RWE Renewables UK Solar and Storage Limited

Planning Act 2008 – Response to advice following issue of decision to accept the application for examination (Section 51 Advice)

Application reference: EN010139

On 8 March 2024, the Planning Inspectorate (PINS) issued a decision by the Secretary of State (SoS) to accept an application made by RWE Renewables UK Solar and Storage Limited (Registered Company No: 14539260) (the Applicant) for an Order Granting Development Consent for the Byers Gill Solar project (the Proposed Development).

Suitability  
**APFP Regulation 5(2)(k)**

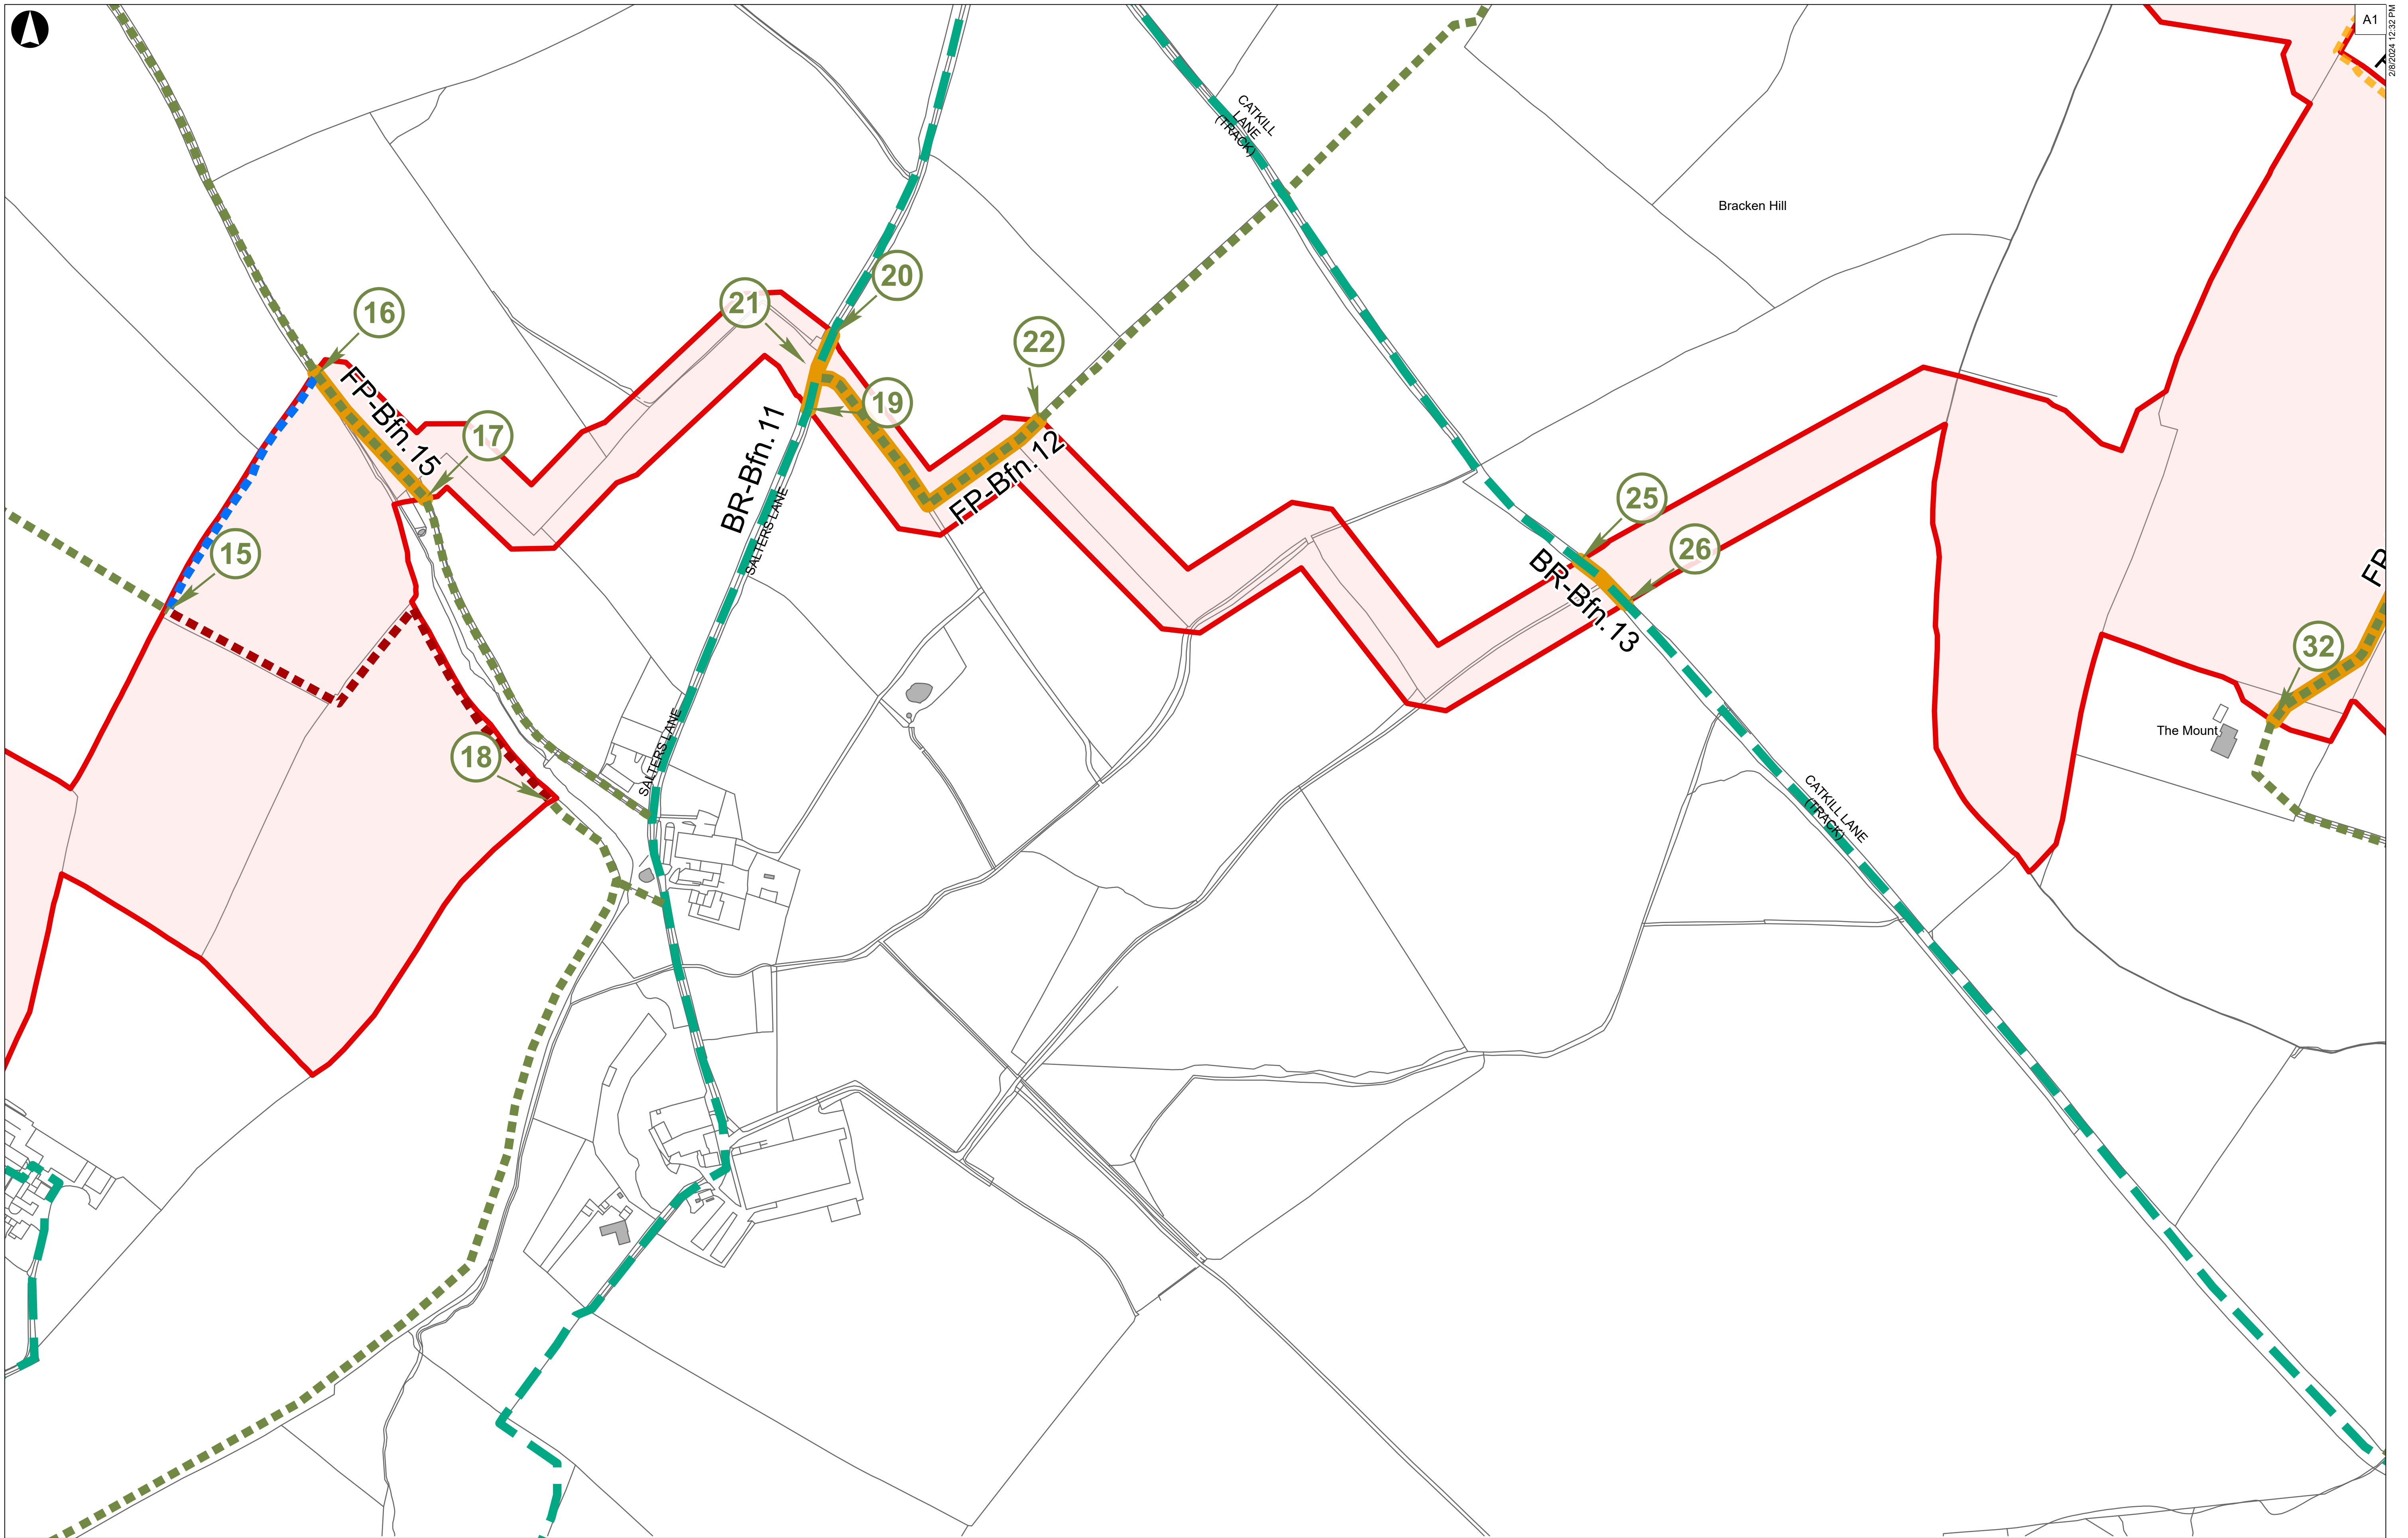
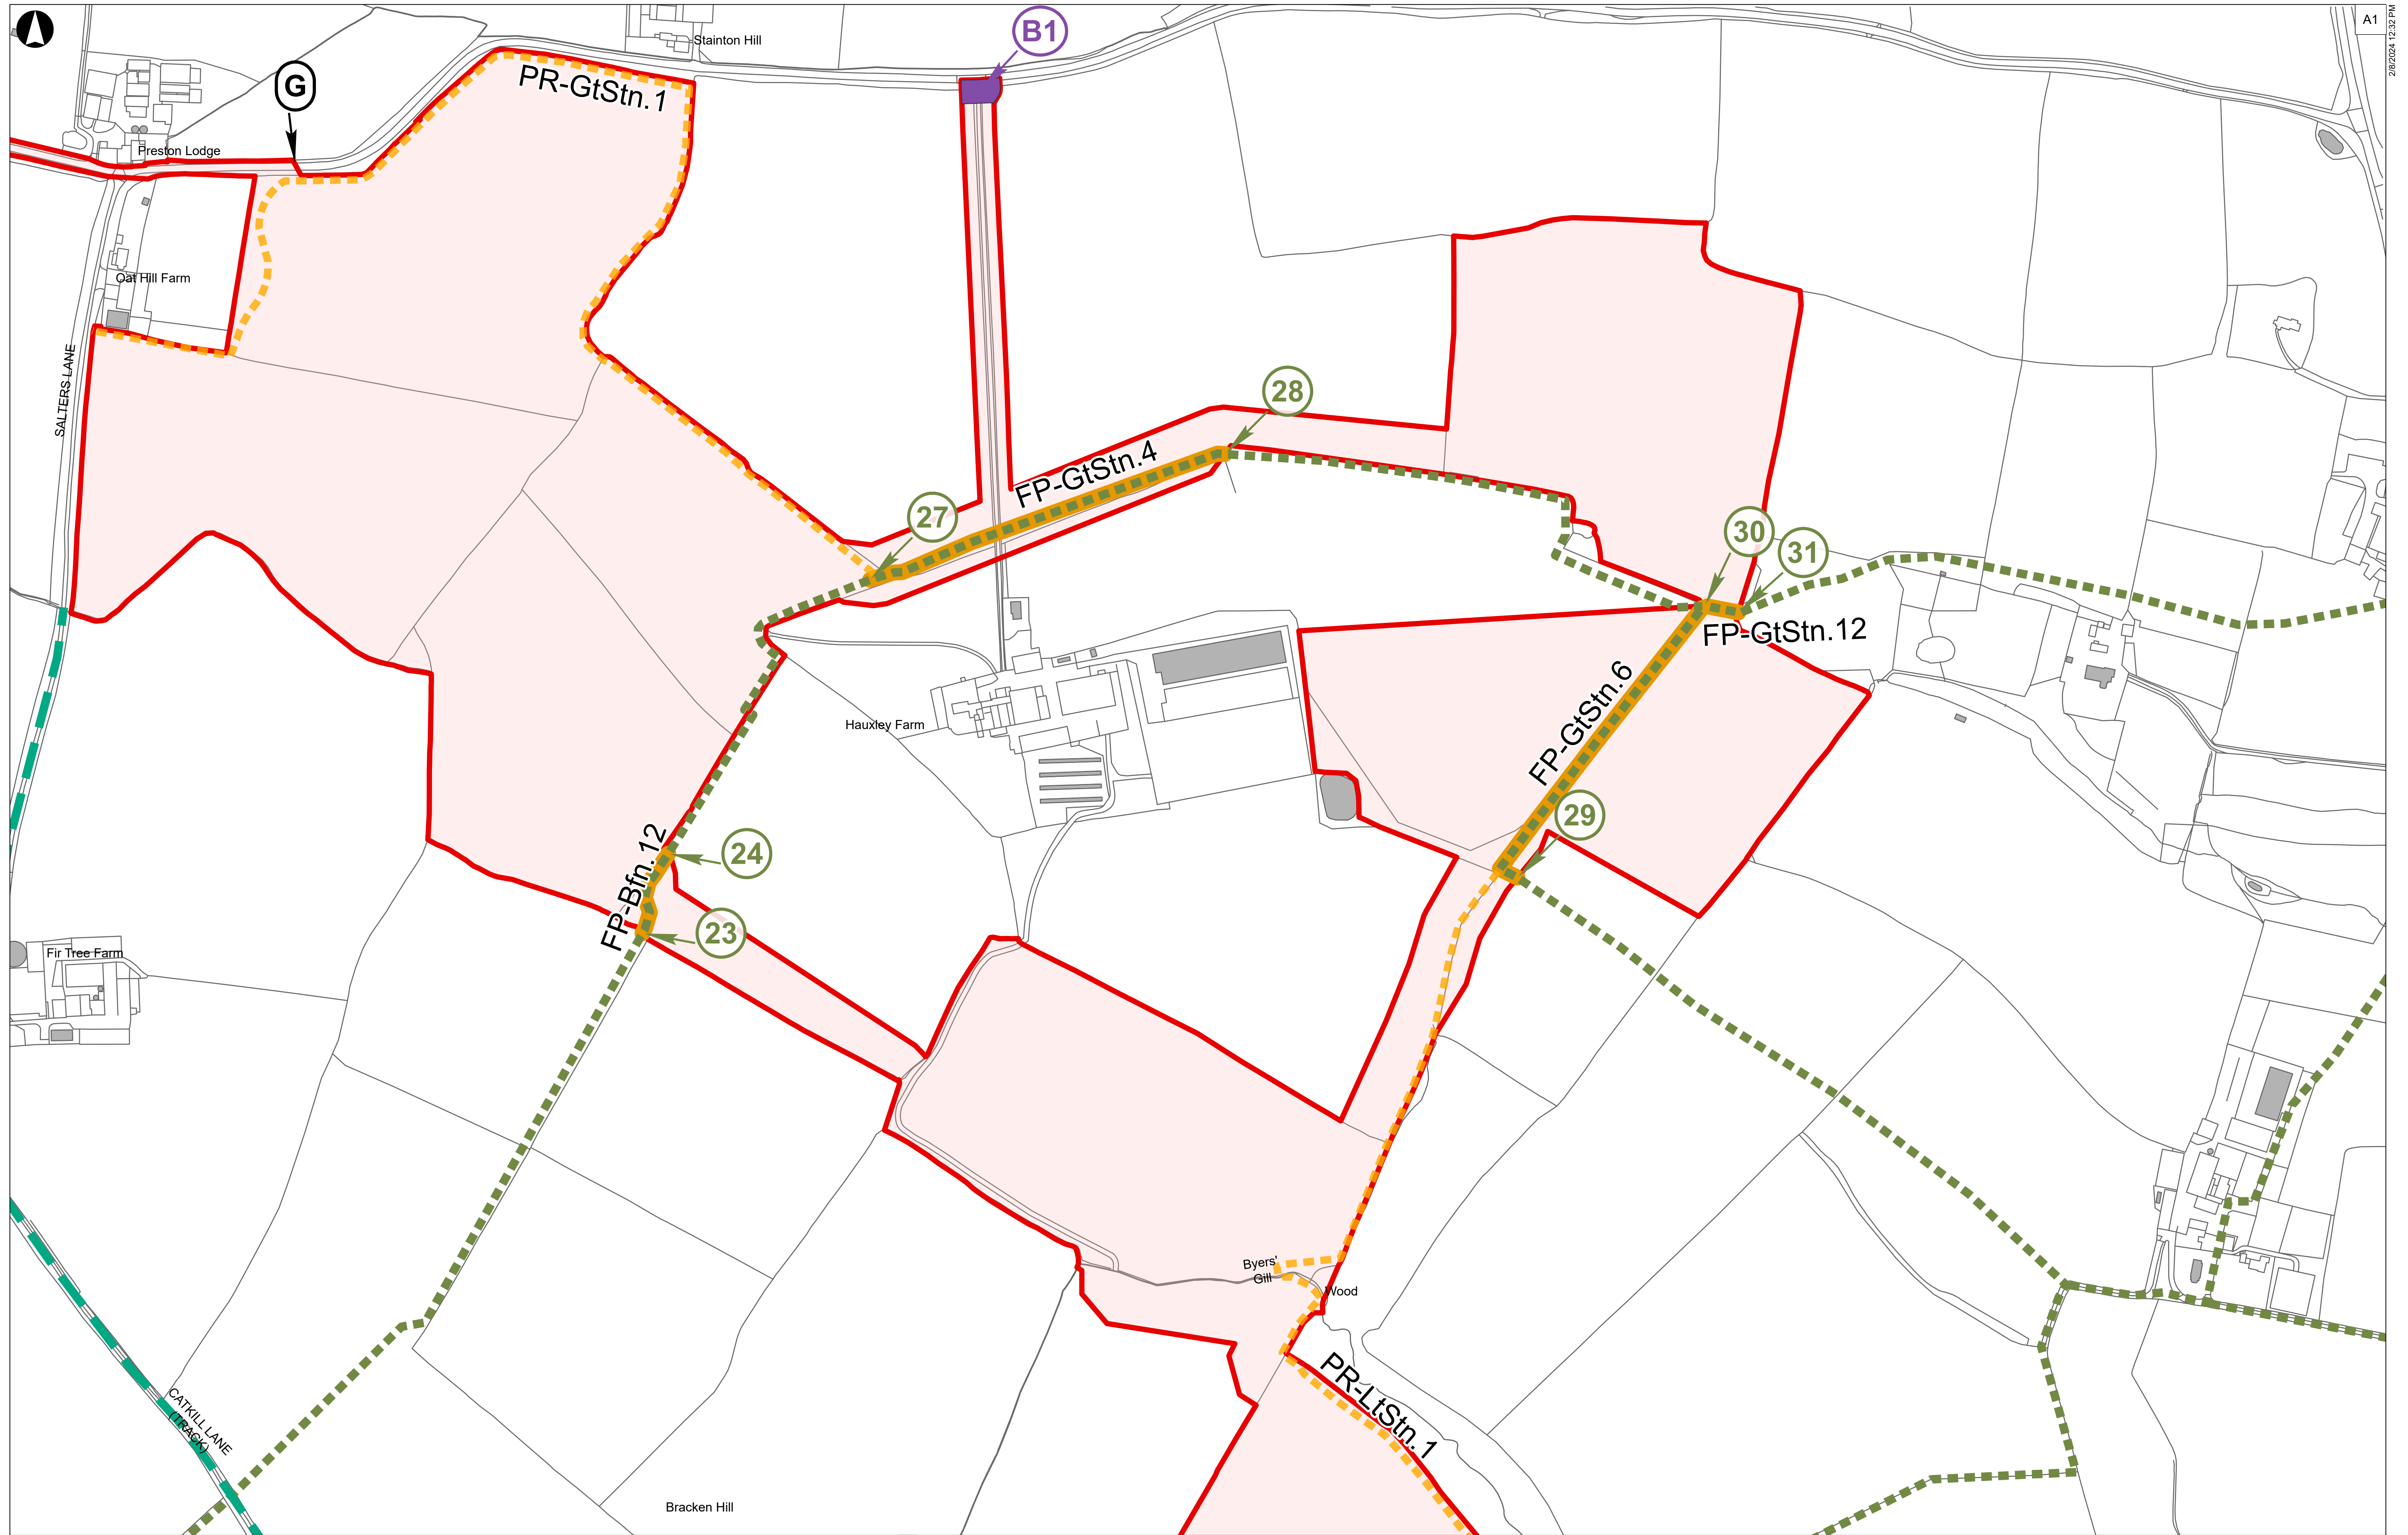
Advice	Applicant Response
<p>Street Works, Rights of Way and Access Plans (Doc 2.3)</p> <p>The Inspectorate notes that there appears to be a lack of consistency across the plan sheets regarding street names and additionally there are some named streets which are referenced in the draft Development Consent Order that do not appear to have been labelled on the plans, e.g. sheet 7 and 8, Elstob Lane. The Applicant may wish to review the Street Works, Rights of Way and Access Plans and amend to ensure consistency and that all roads listed are labelled across all plans. It has also noted that the legend is not consistent with the approach taken for the Land Plans in terms of listing only the details as reflected on the sheet. The key reflects various types of street works, even though the relevant sheet appears to not show the streets works as depicted in the legend. The legend on each sheet should be limited to what is present on that particular part of the plans; e.g. sheet 1, legend should not include 'A' streets subject to street works'. Consistency must be evident across all plans. The order of the sheets in the Street Works, Rights of Way and Access Plans is not consistent with that of the Key Plan included in the Works Plans (Doc 2.2) or the Land Plans (Docs 2.4). In addition, the Street Works, Rights of Way and Access Plans does not appear to actually match the layout of the key plan and does not appear to correspond to the order in which the sheets of the Street Works, Rights of Way and Access Plans are actually set out.</p>	<p>The Applicant acknowledges the inconsistencies identified by PINS in relation to the Street Works, Rights of Way and Access Plans (Document Reference 2.3). The Applicant has reviewed the advice provided by PINS and has produced a revised set of these plans, submitted alongside this letter.</p> <p>The amendments made to the plans under this revision seek to address the issues identified and have included:</p> <ul style="list-style-type: none"> • Updates to the key plan so that it is now consistent with the Works Plans (Document Reference 2.2) and Lands Plans (Document Reference 2.4). Please note that this change is to the order of the key plan only, and therefore does not impact on the Schedules of the dDCO which cross-reference these plans. • The Legend on each sheet has been amended so that it only shows what is visible on each individual sheet. • A review of the plan's labels against the dDCO Schedules has been undertaken and new labels added in so that they are more easily cross-referenced. <p>The revised plans (Revision 2) are provided to PINS to supersede those submitted at the point of DCO application.</p>
